Our Ref: 19334

10 June 2026

**RE: WSU MILPERRA – 2 AND 2A BULLECOURT AVENUE, MILPERRA (SSD- 7092958)
 PROPOSED DESIGN MODIFICATION OF ROAD 2B TO RETAIN TREE 56
 TRAFFIC STATEMENT**

- 1) *SSDA Design 1*
- 2) *Amended Design 2*

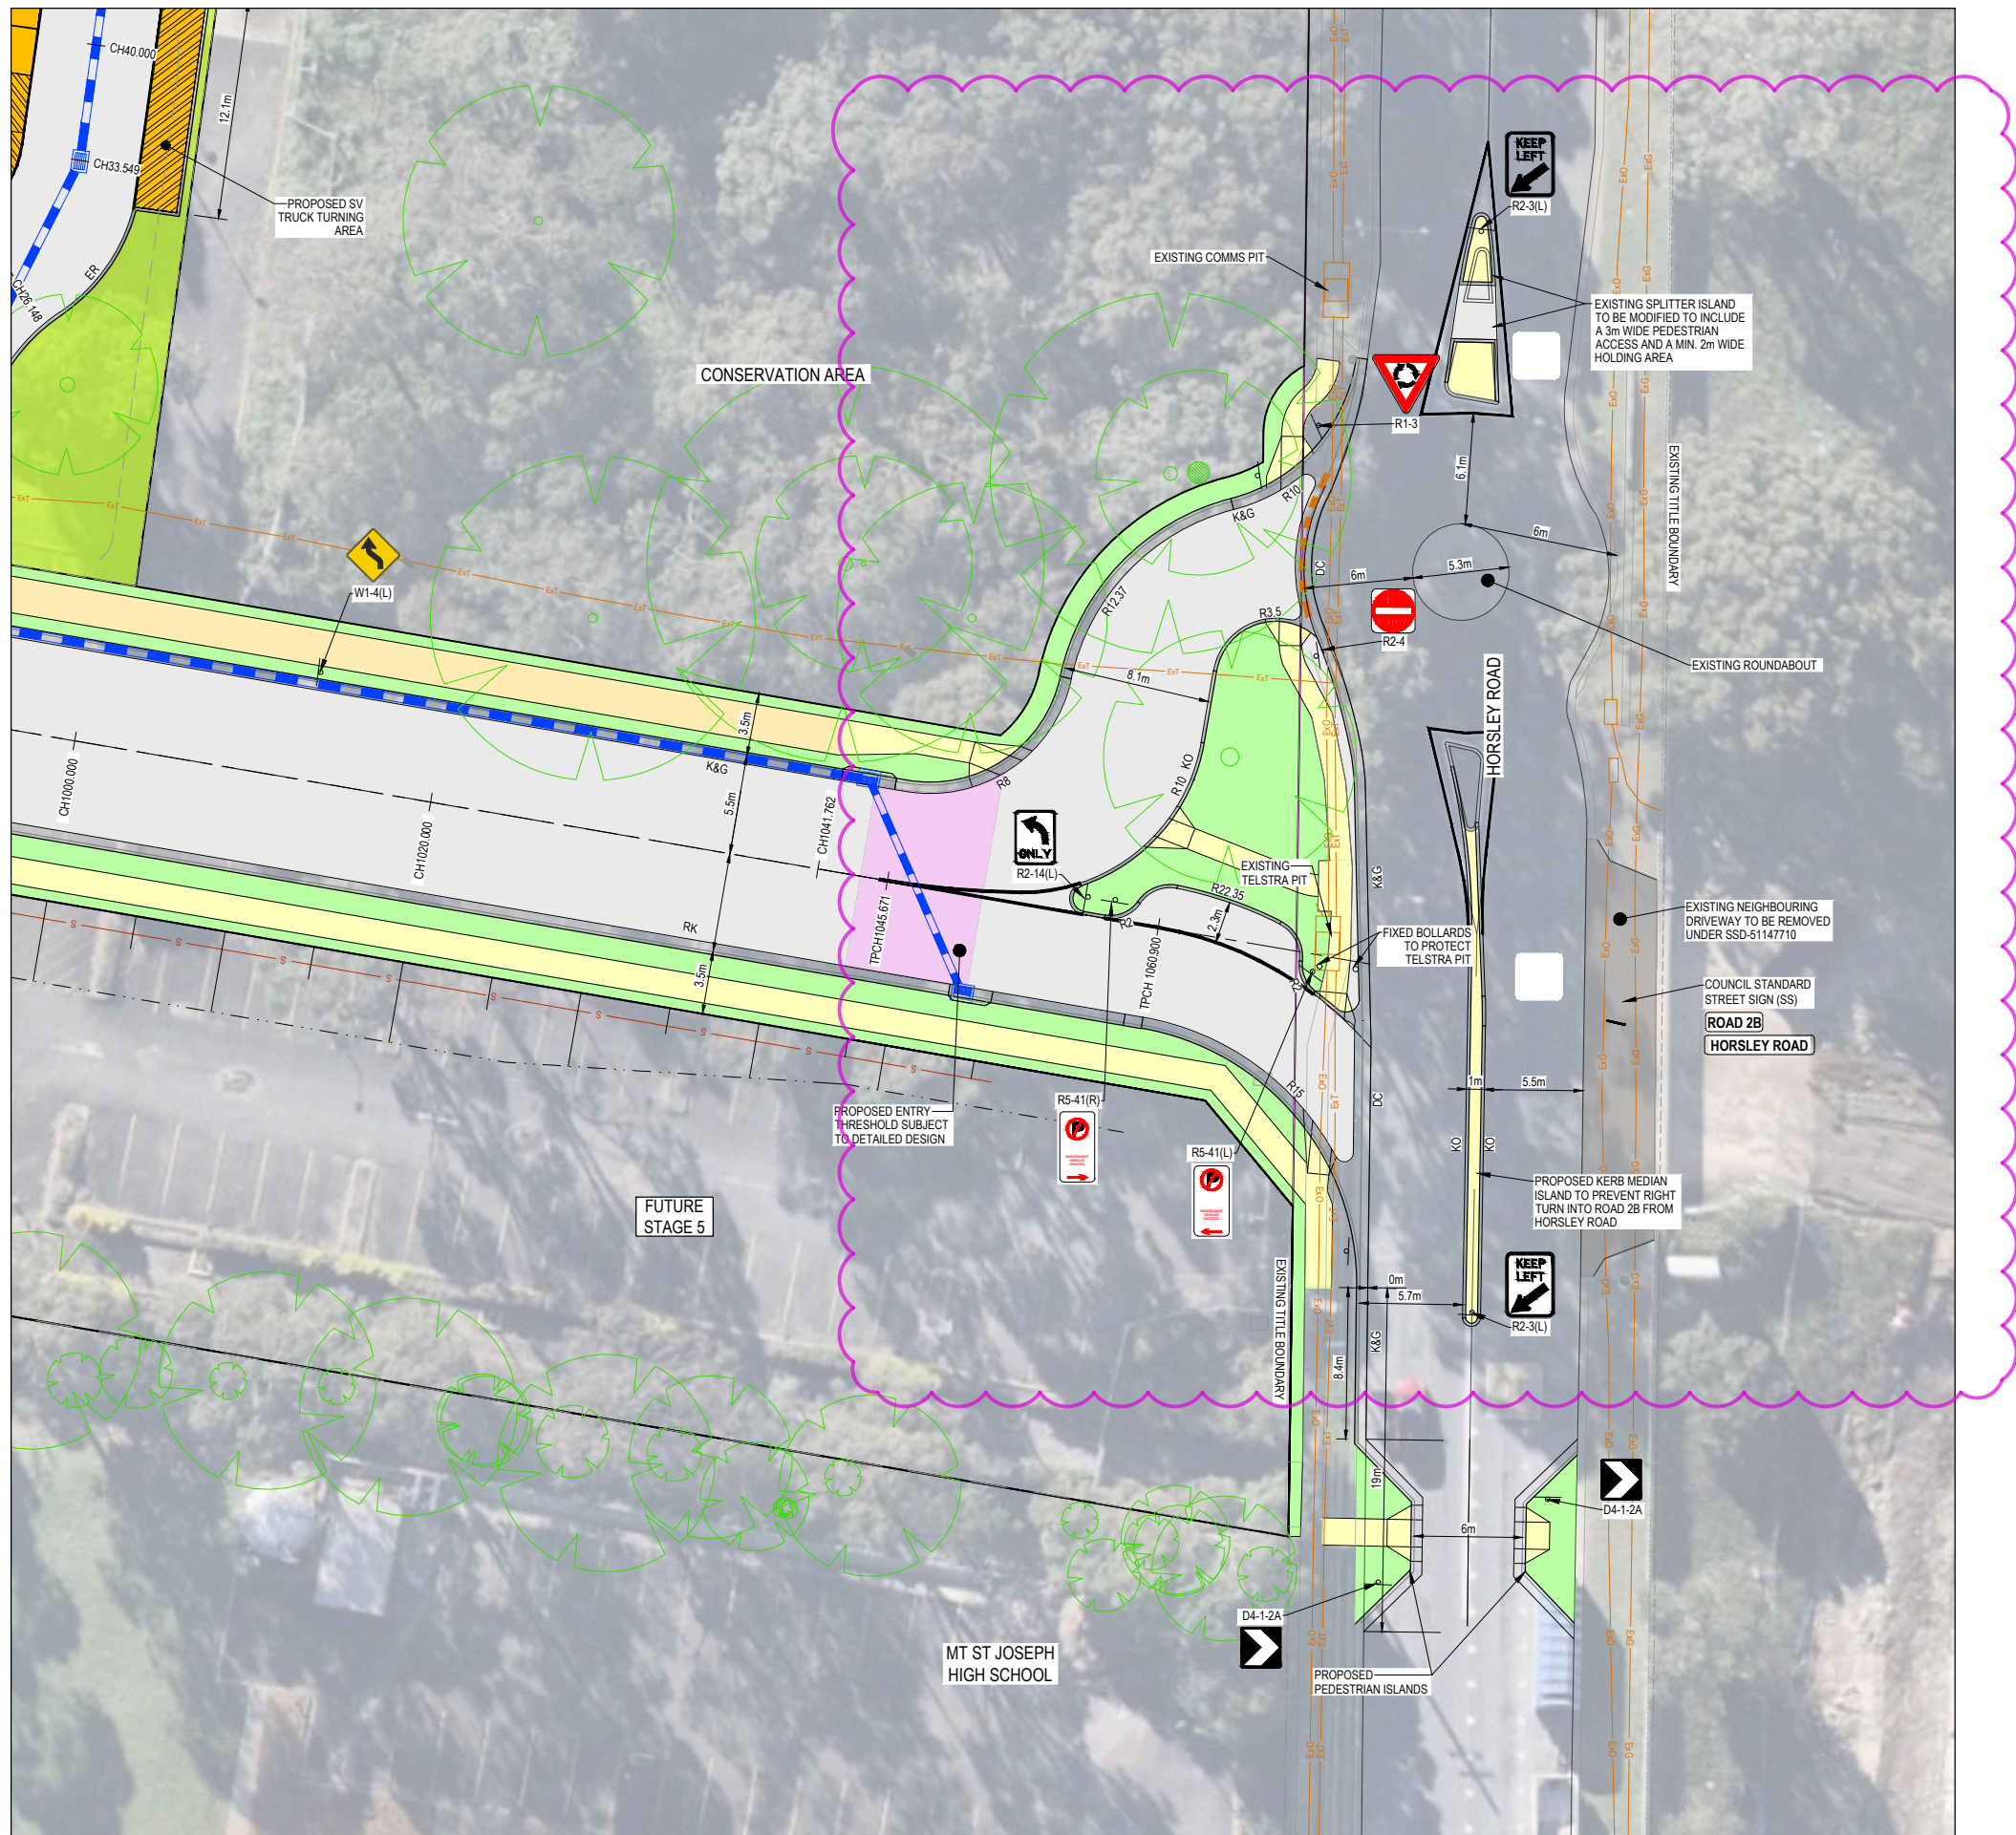
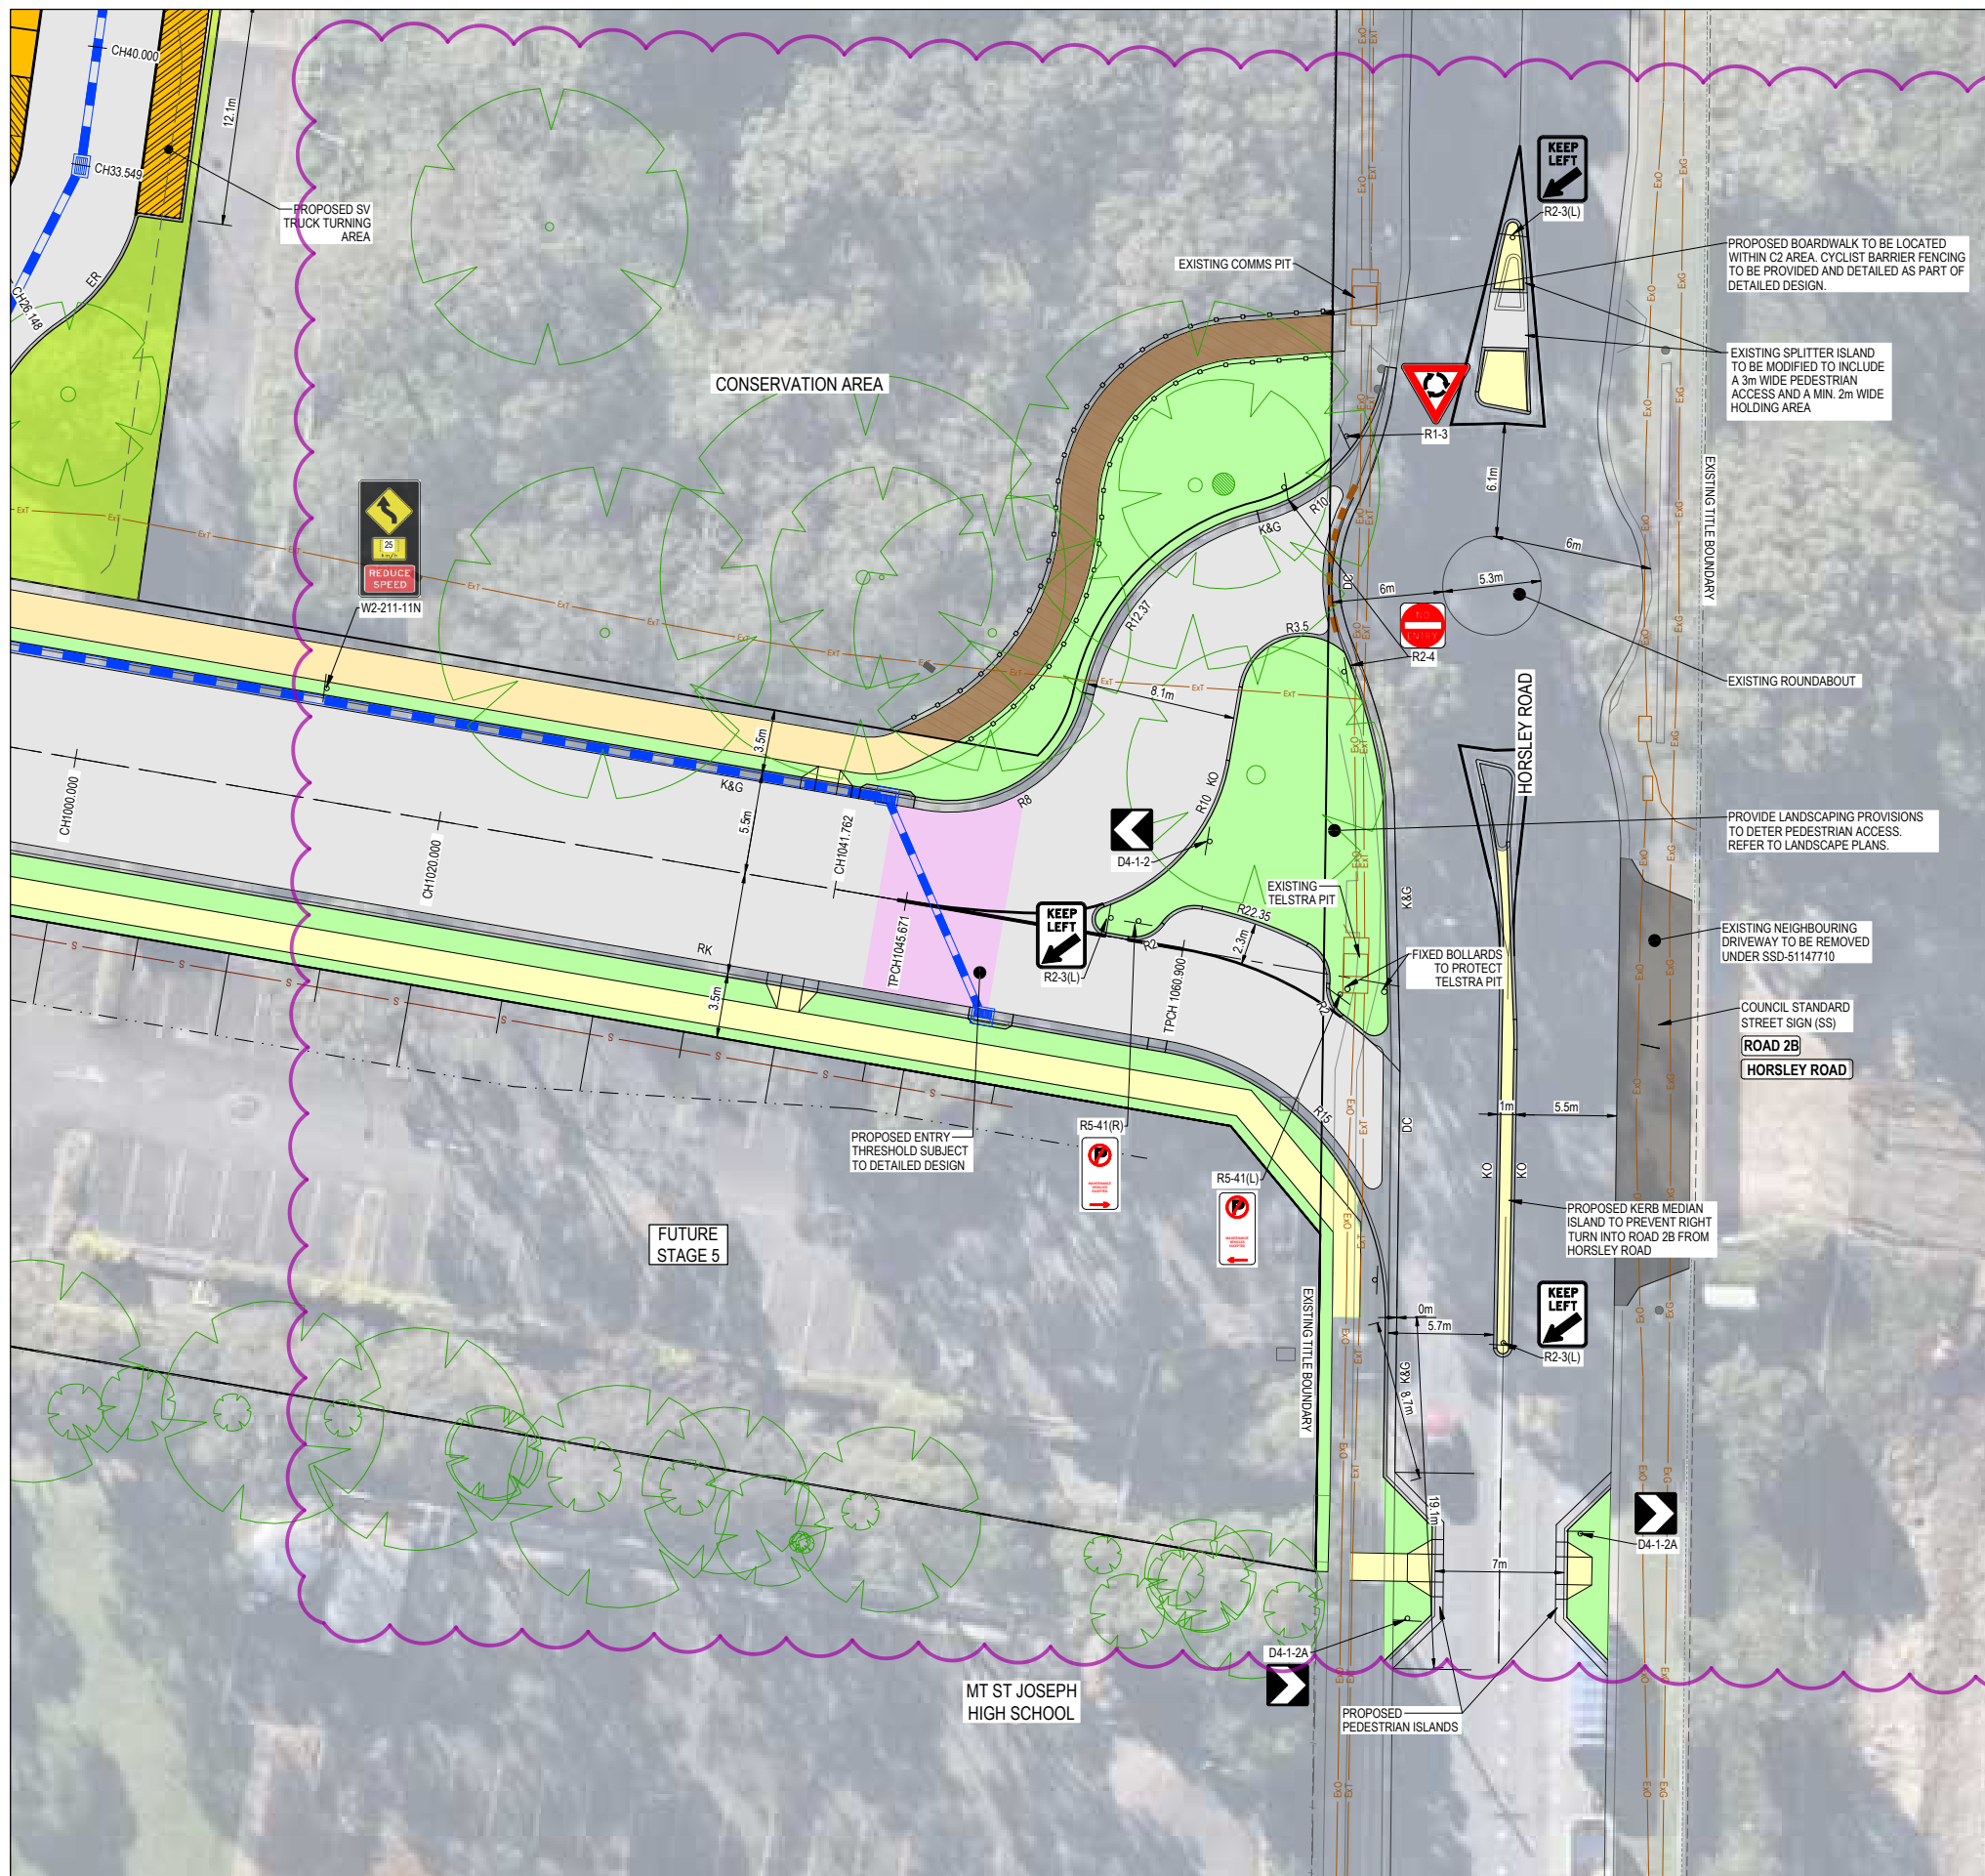
The proposed design modification involves introducing a kerb extension approximately 20m length into the 2.5m wide kerbside parking lane, to accommodate a pedestrian footpath around the tree.

The original design of Road 2B proposed an 11m wide carriageway, comprising a 3m wide traffic lane and a 2.5m wide parking lane in each direction of the road. As the proposed kerb extension will be built into the parking lane, the proposed modified design will still maintain an 8.5m wide carriageway along the proposed kerb blister.

As a 3m wide traffic lane is maintained for the eastbound traffic, the proposed kerb extension will not impact the traffic movements along Road 2B.

The proposed kerb extension will result in the loss of approximately three car parking spaces on the northern side of Road 2B. However, this will not have a material impact on the overall on-street parking supply of the development.

A pedestrian footpath will be constructed around the tree, with a provision of a kerb ramp on the kerb blister connecting with the footpath. Therefore, the proposed design modification will not impact pedestrian movements in the area.

Notwithstanding this, it is our recommendation that additional edge linemarking from the kerb return to the kerb extension, a hazard marker sign on the kerb extension and 'NO STOPPING' signage be installed to improve the safety of traffic movements in the area and ensure a 3m wide traffic lane is available in each direction of the road.

Based on the above review, it's TTPP's advice that the proposed kerb extension on the northern side of Road 2B for the purposes of retaining a tree, is acceptable from the traffic perspective.

The proposed kerb extension will still maintain a 3m wide travel lane in each direction of the road, thus will not impact traffic movements on Road 2B.
